Recommendation Report for Planning Permission for Works or Extension to a Dwelling

REF NO: R/279/21/HH

LOCATION: Spindrift
The Roundway
Rustington
BN16 2BW

PROPOSAL: Erection of single storey rear extension, partial conversion of garage to habitable use, extend front porch with pitched roof, new pitched roof over existing front flat roof. Alterations to fenestration/openings, render to elevations and new roof covering.

PROJECT NO. 1918
DWG NO. 1918.11 FP

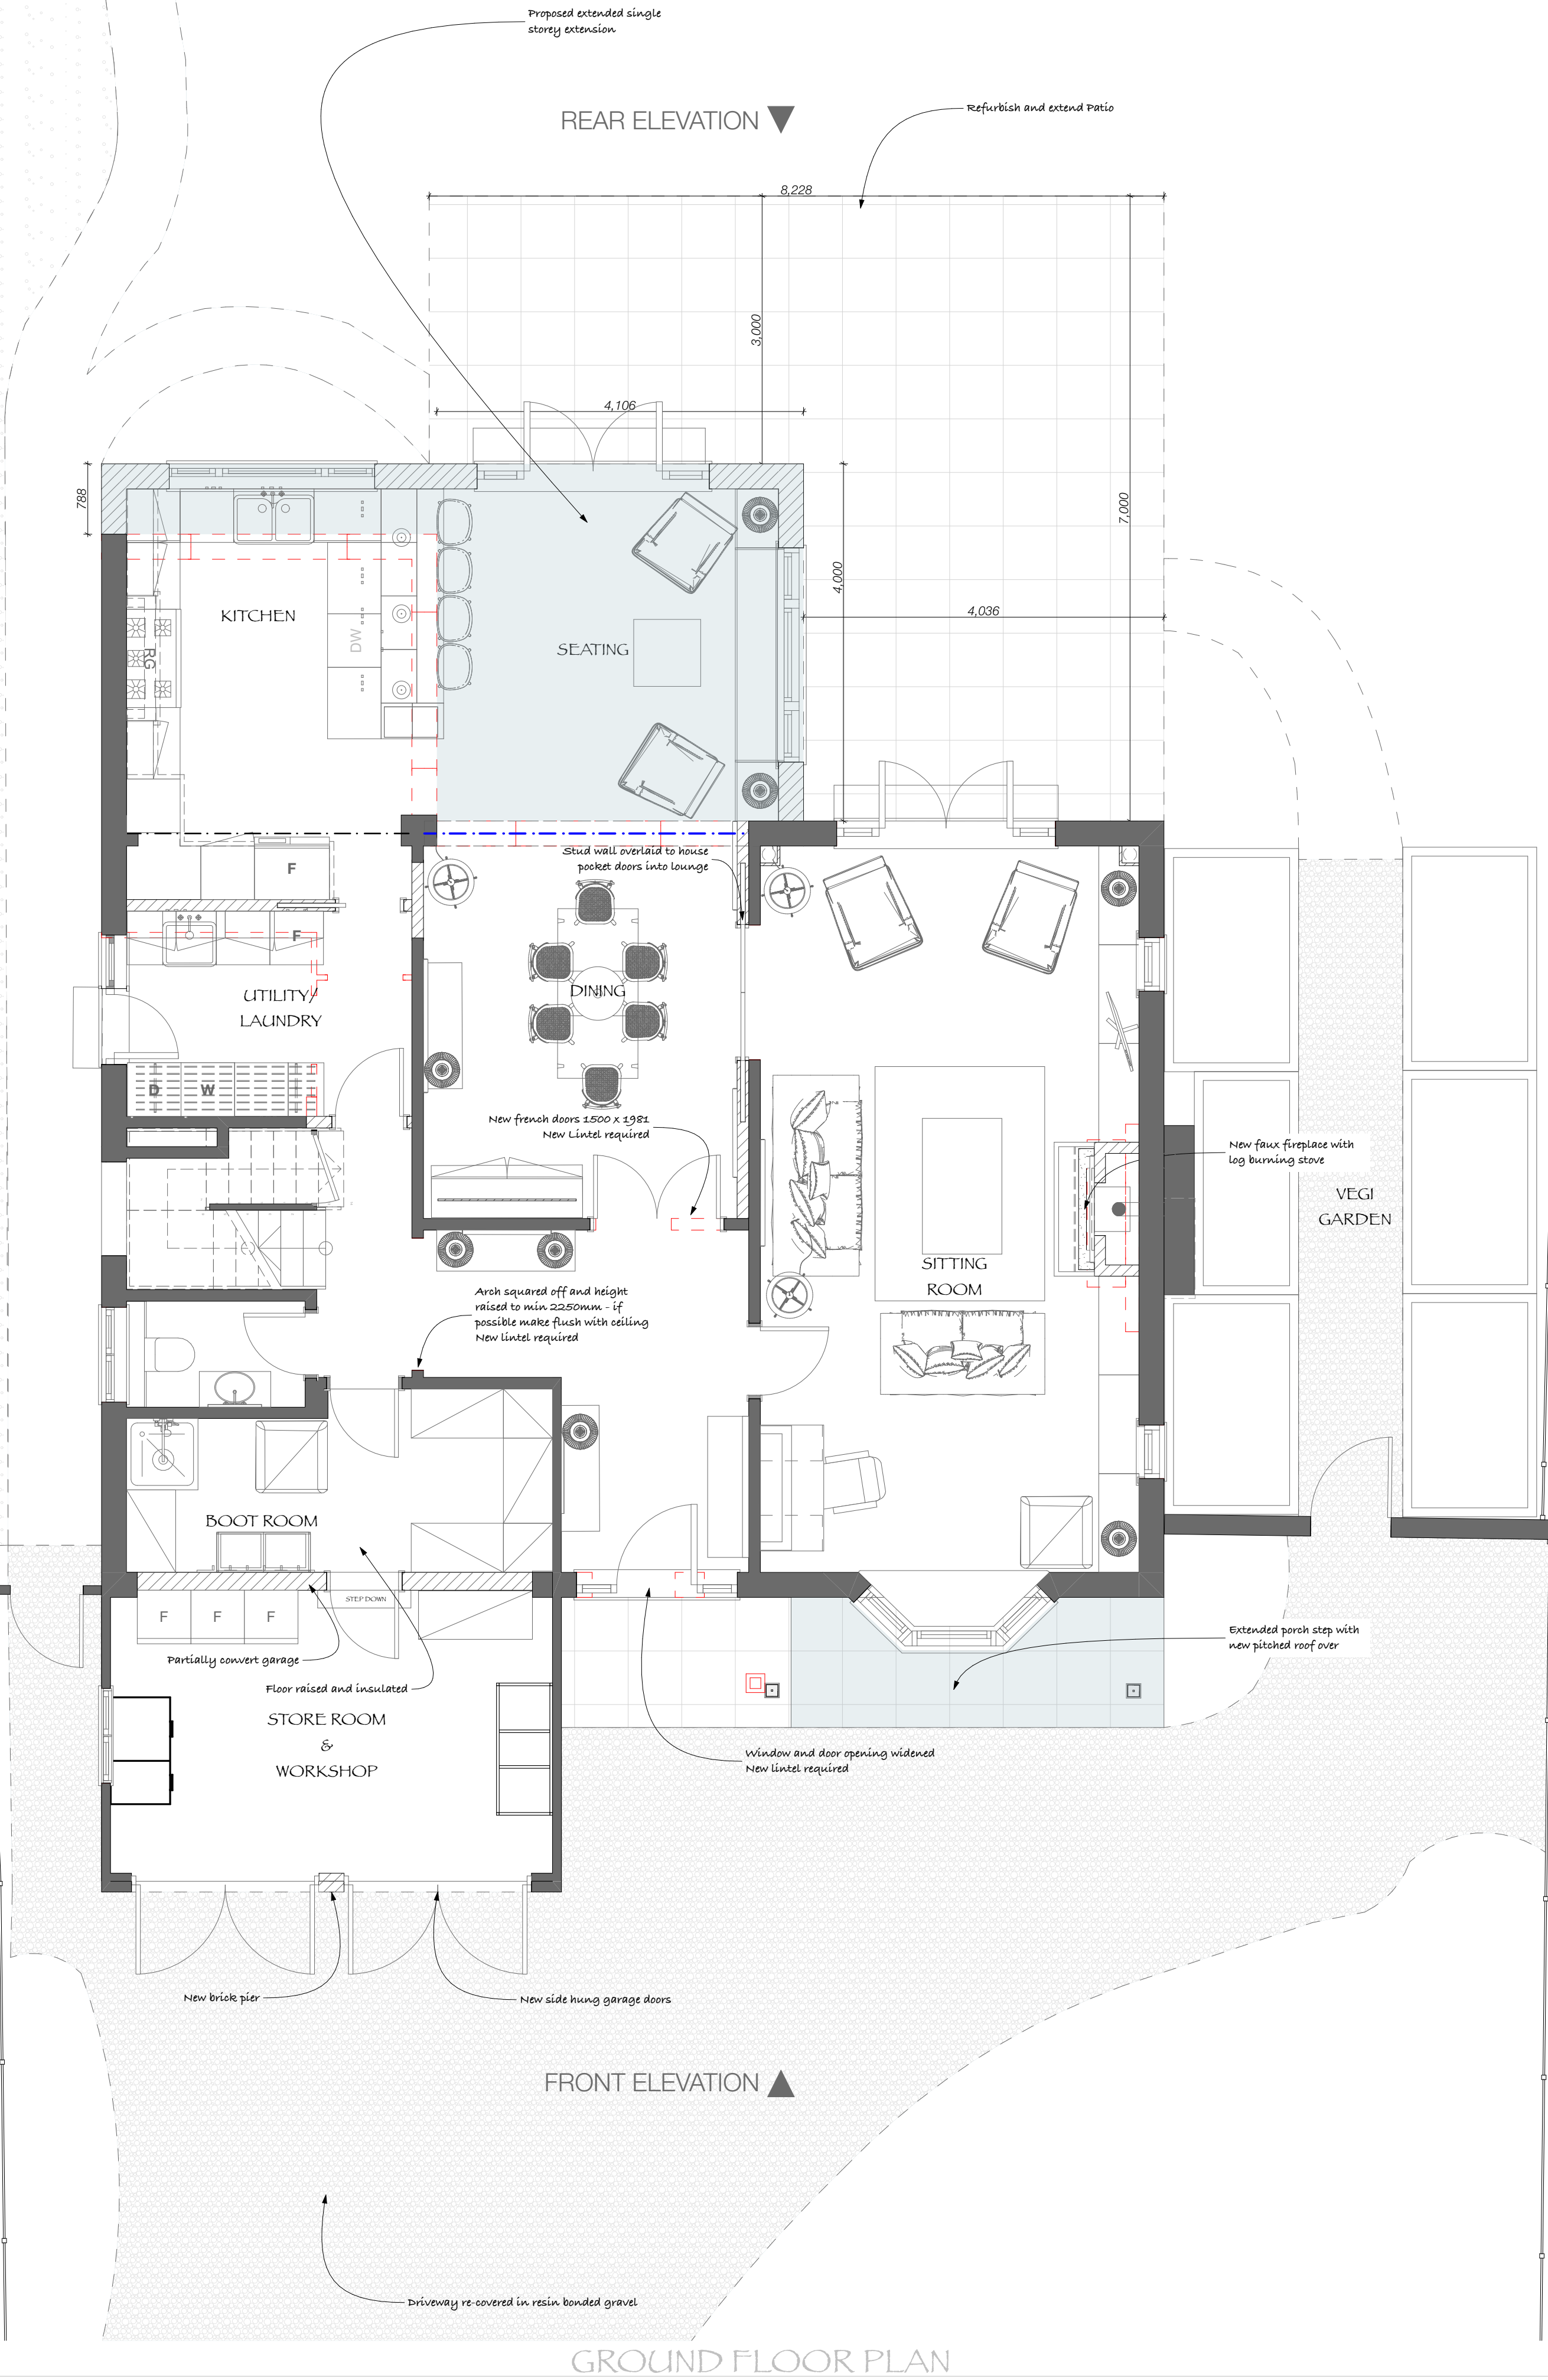
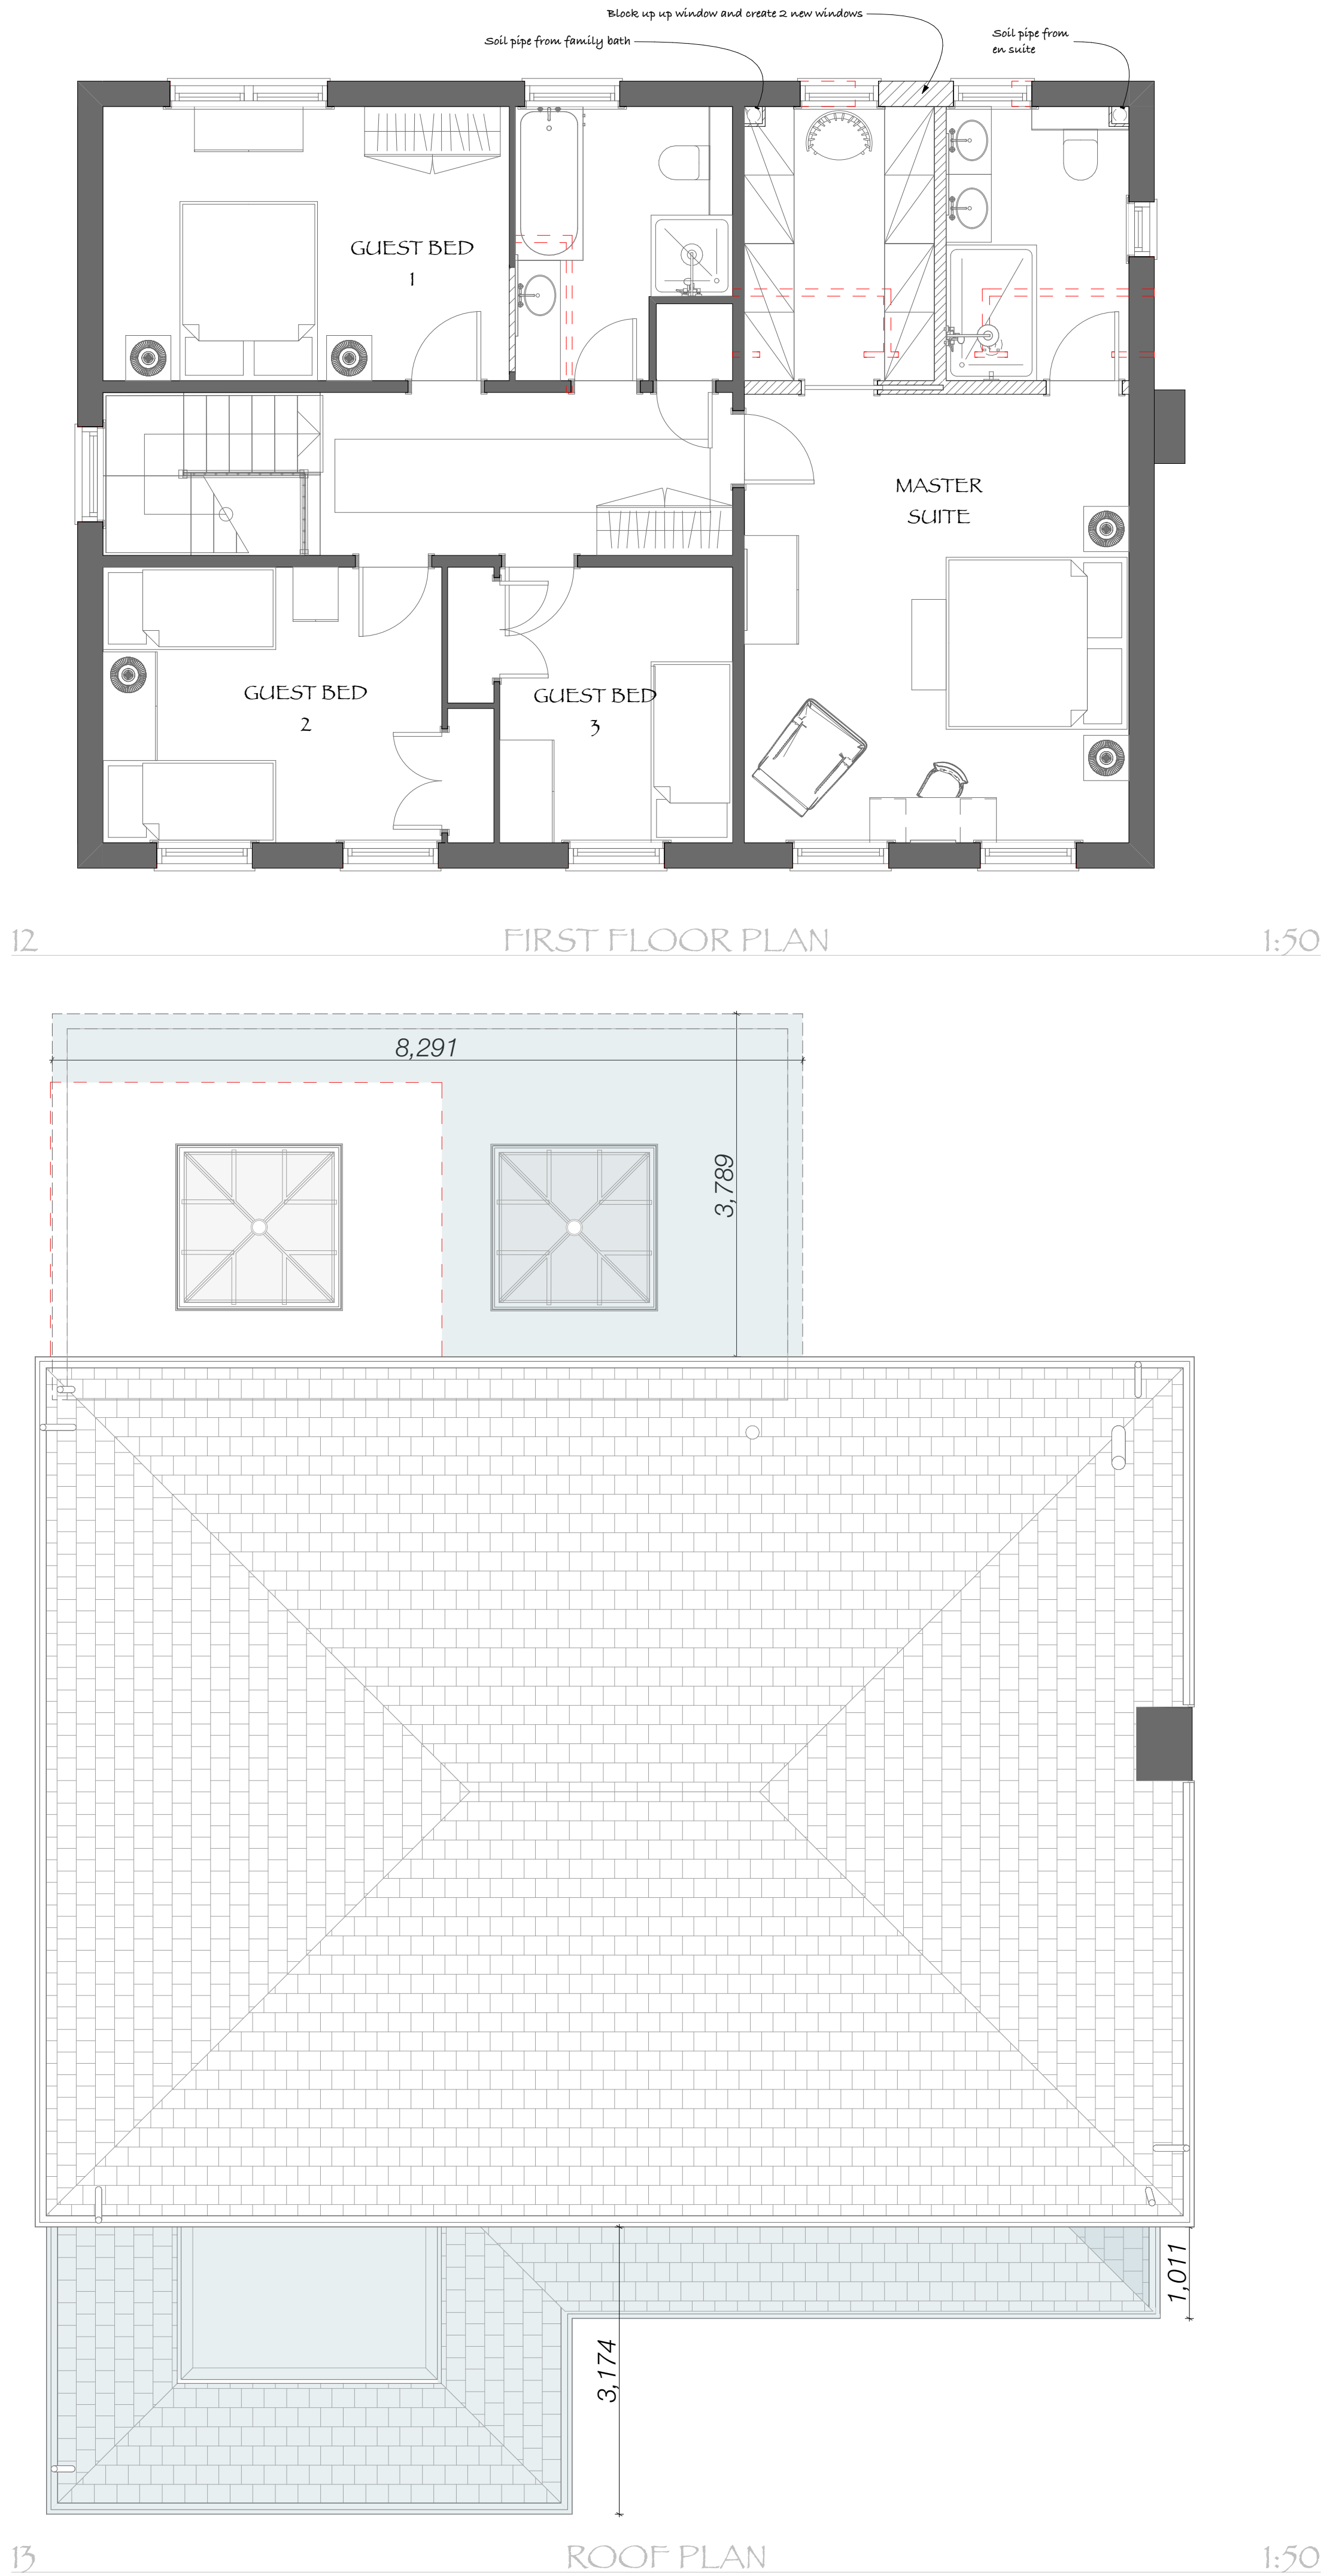
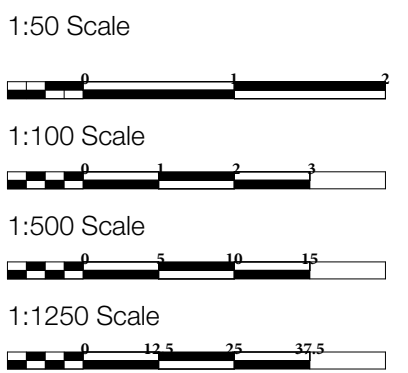
It is proposed to construct a rear extension in place of an existing flat roofed extension measuring in total 8.29m in length and 3.79m in depth. The existing structure measures 3.8m in width by 3.1m in depth. Additionally, the existing flat roofed, partially integral garage, is to gain a pitched roof which will also run atop the existing flat roof porch and over an existing bay window, creating a storm porch.

In terms of overbearing and overshadowing, the proposed rear extension will not encroach on the separation distances to side boundaries. A rear garden of 8.4m will be retained, this is lower than design guidance recommends, however, it will only be lowered to this amount over part of the rear garden (as the extension does not run fully across the back of the house).

The 45-degree rule for rear extensions is to be adhered to. The overall height of the rear extension will be raised by only 100mm above that of the existing roof structure.

PROJECT NO. 1918
DWG NO. 1918.13 FP

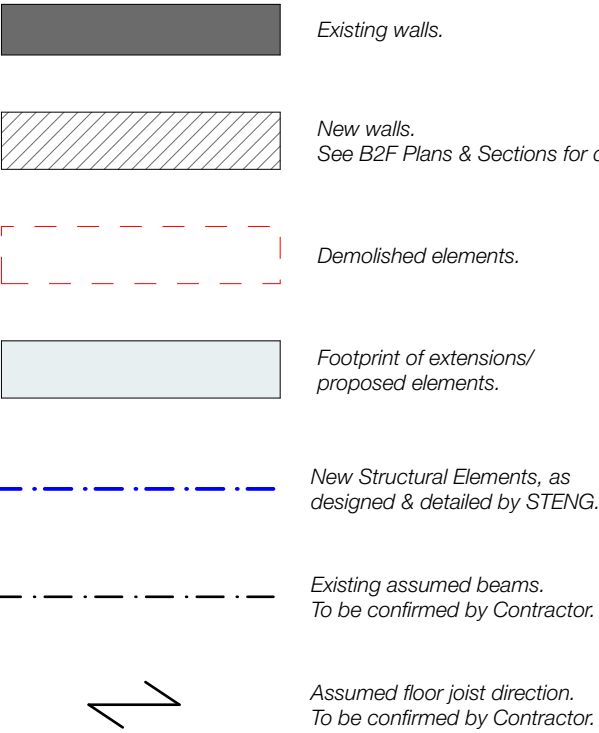
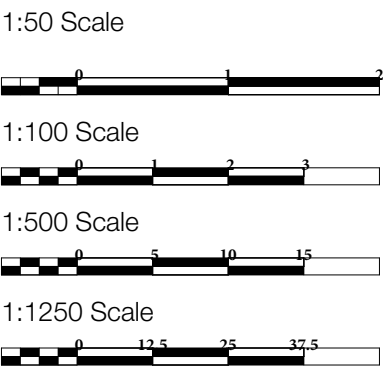
New fenestration will face towards the rear and southern boundaries and be located at ground floor level where it is generally accepted that no negative impacts from overlooking will arise. Alterations to a single window to form two smaller windows have been proposed at first-floor level to the eastern elevation (rear). As the amount of opening is of similar proportions to existing conditions no negative impact will arise from this.

PROJECT NO. 1918
DWG NO. 1918.12 FP

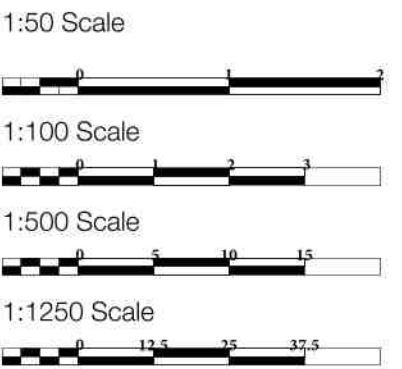
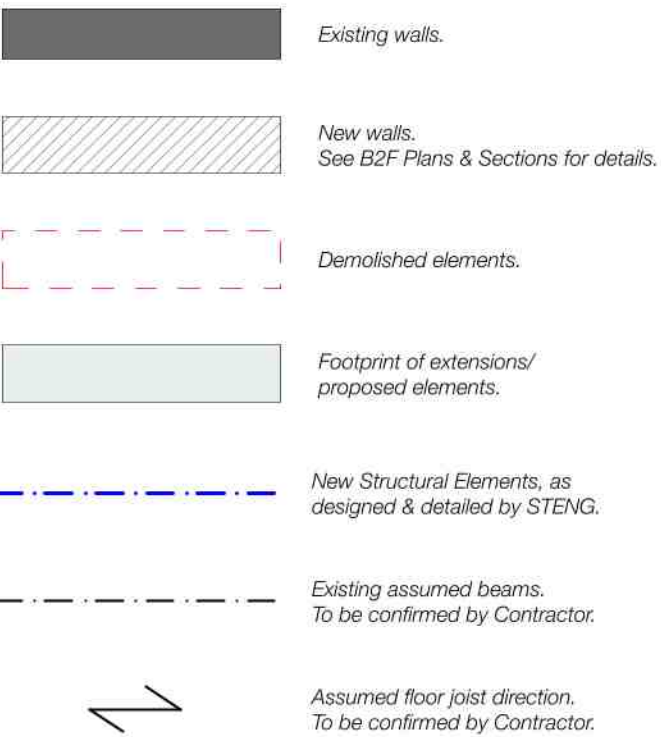
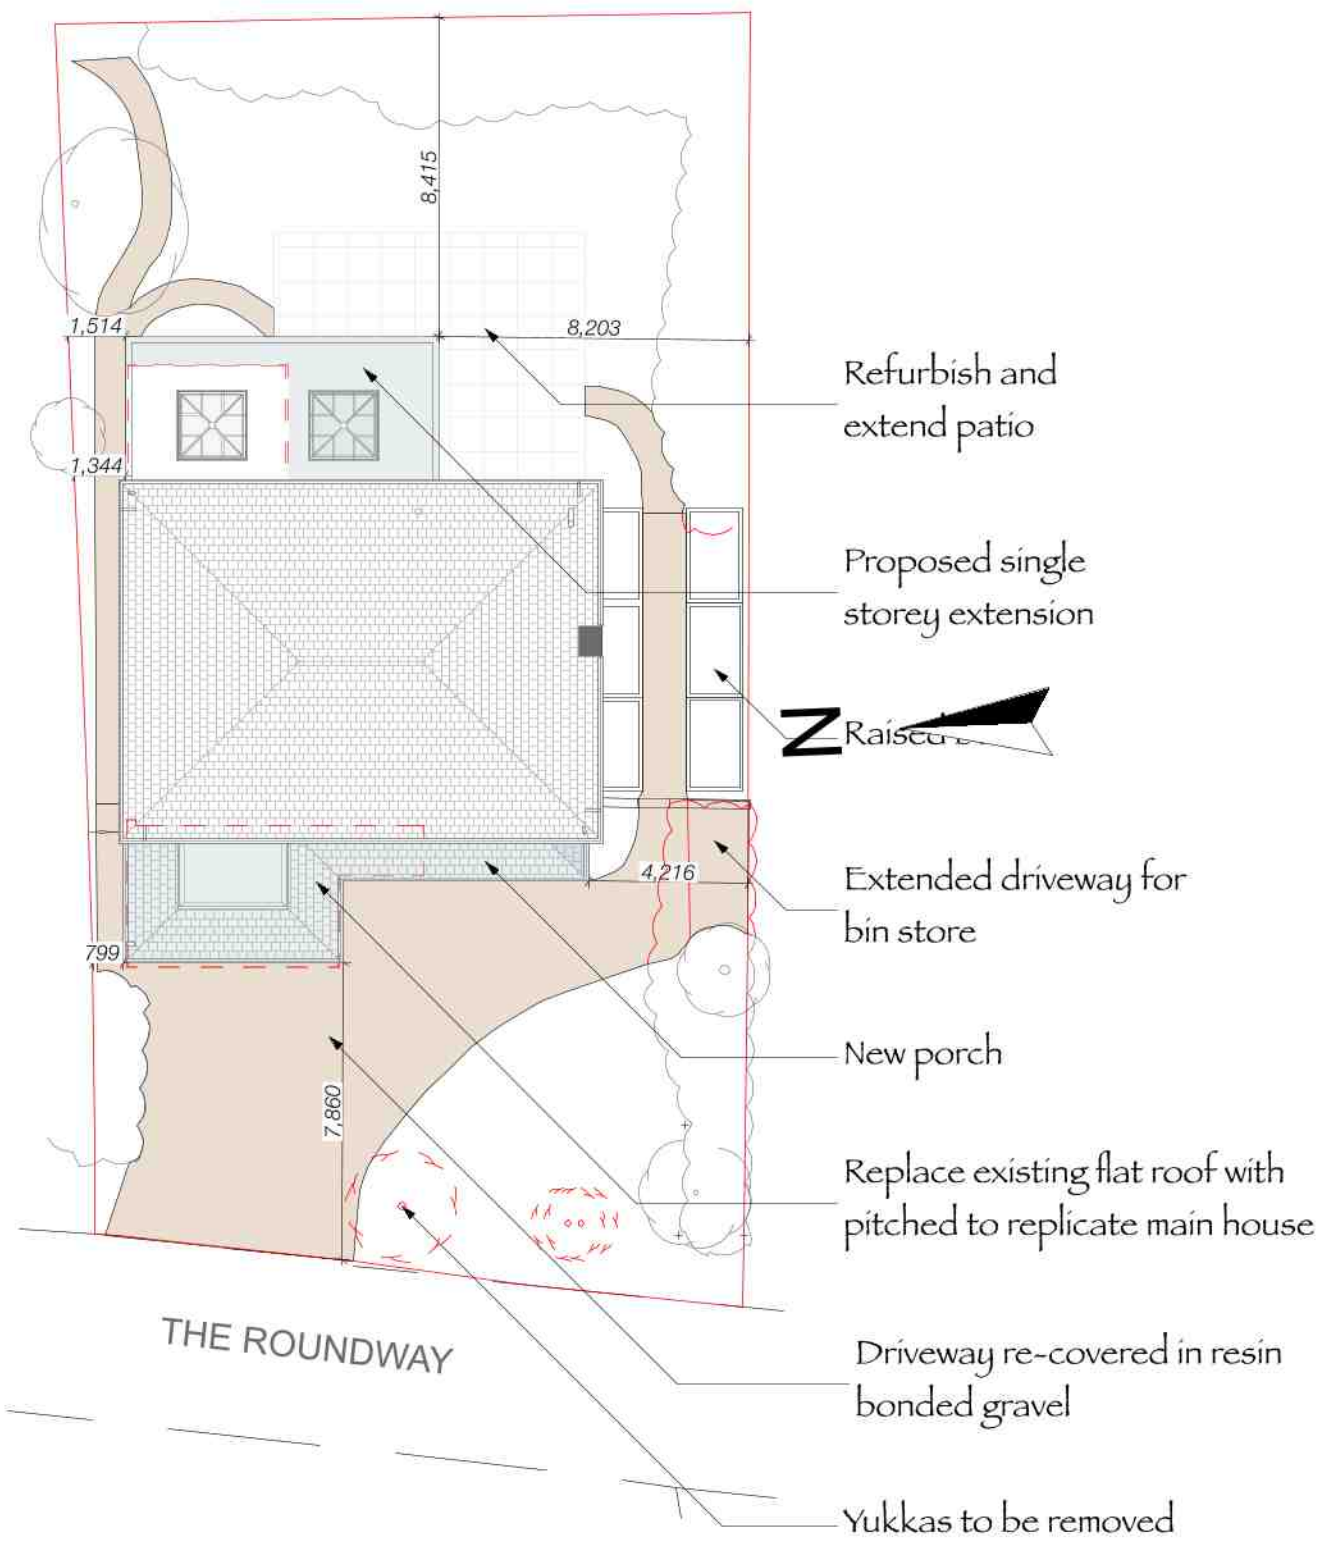
The alterations to the front of site, including a new pitch roof running along the dwellings frontage is an attractive addition. No new floor area will be created by the proposed works to the front of the building and the building line will be retained. The new pitched roof will be 700mm taller than the existing flat roof. The combination of the front protrusions (garage, porch and bay window) under one roof structure gives a harmonious feel to the frontage and appears visually integrated with the host dwelling.

The alterations to the garage/porch do not increase the footprint of the building and only minimally increase the height of the structure.
